DEVELOPMENT
MANAGEMENT

Chichester District Council
Re: Notice of a Planning Application
Planning Application: 23/02747/DOM
Proposed loft conversion and alterations to the roof form,
external changes to the properties elevations.
15 Ashburnham Close Chichester West Sussex PO19 3NB

Proposed Site Plan

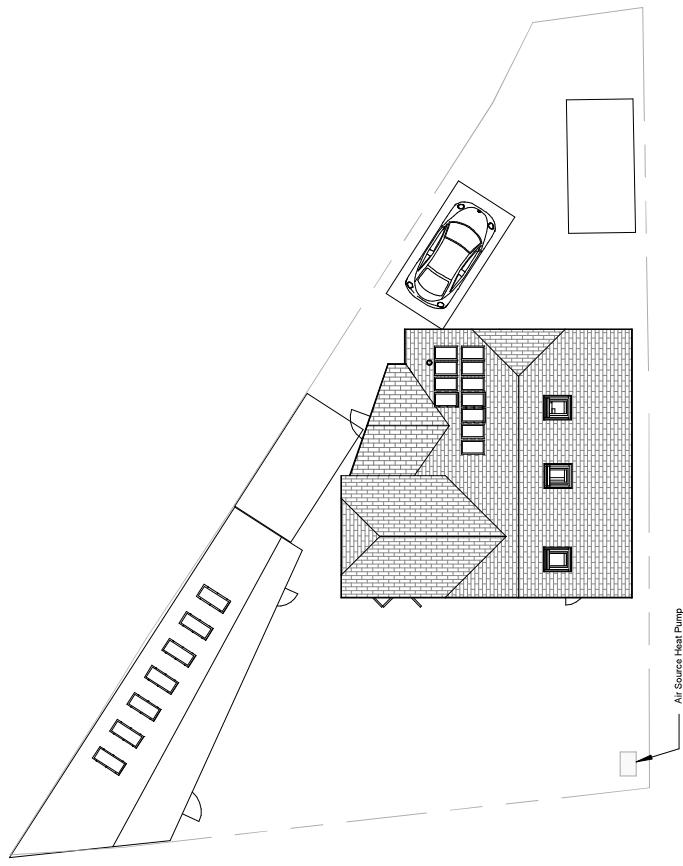
The planning committee may also wish to consider the site of the proposed Air Source Heat Pump in the (near) right angle of the properties rear boundary. This site is directly below an established mature Mimosa tree. The excavation of the ground to instal the heat pump will necessarily cut into the root system of the tree and may cause its death. The conservation of trees in the Council's area of responsibility is a matter that I am sure the council takes very seriously and it would wish to do nothing avoidable that may harm the environment.

SHEET
Elevations-Front/Rear

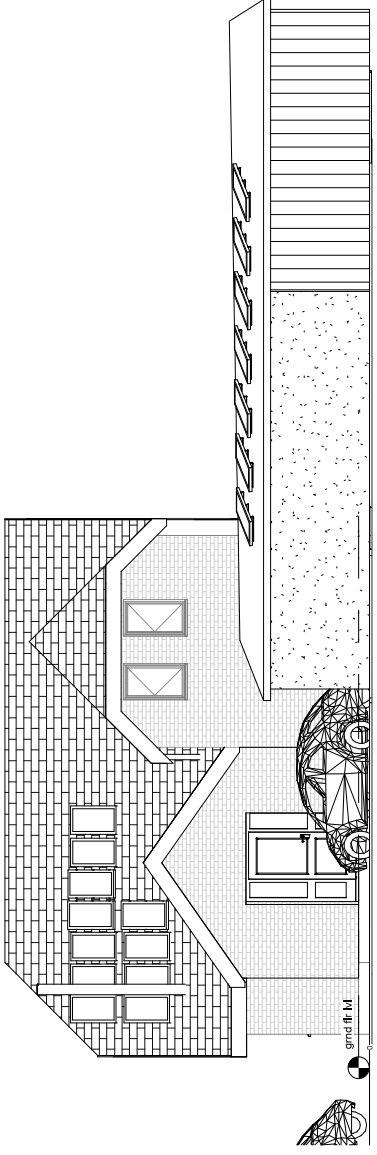
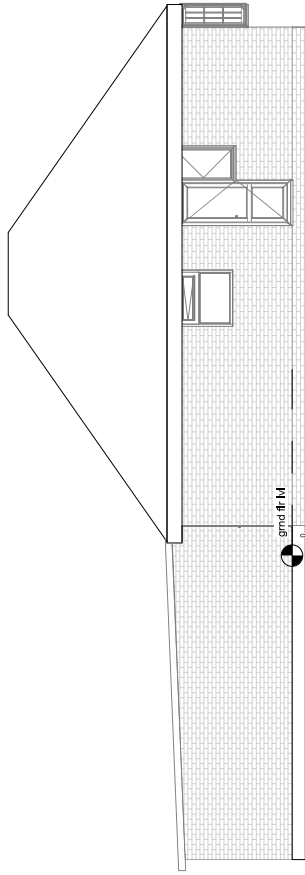
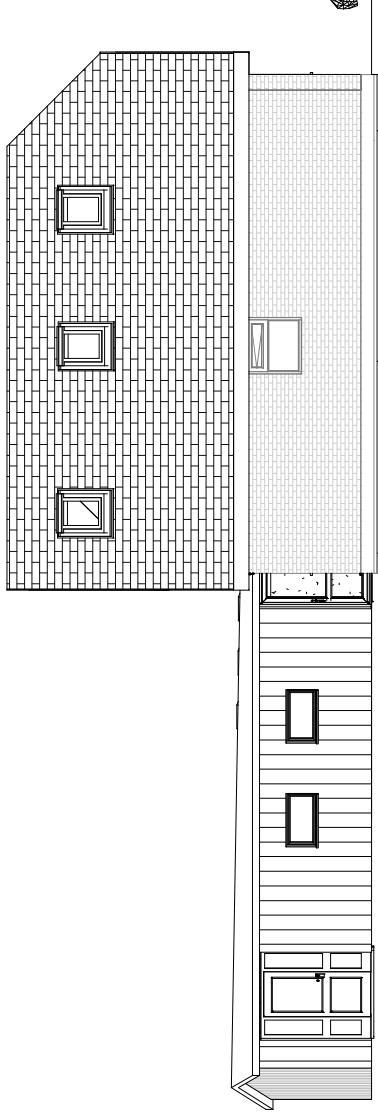
The planning application for the development of 15 Ashburnham Road as listed above proposes a change in the vertical height of the roof line and the inclusion of three "Velux-style" windows at the rear of the building. The orientation of the roof remains unchanged. It is estimated from the architectural drawings supplied by Parkers Executive Design that the height of these three roof windows will allow an adult of average height to look out into the neighbouring gardens. This aspect of the design will necessarily intrude on the privacy of the gardens they overlook and is unacceptable.
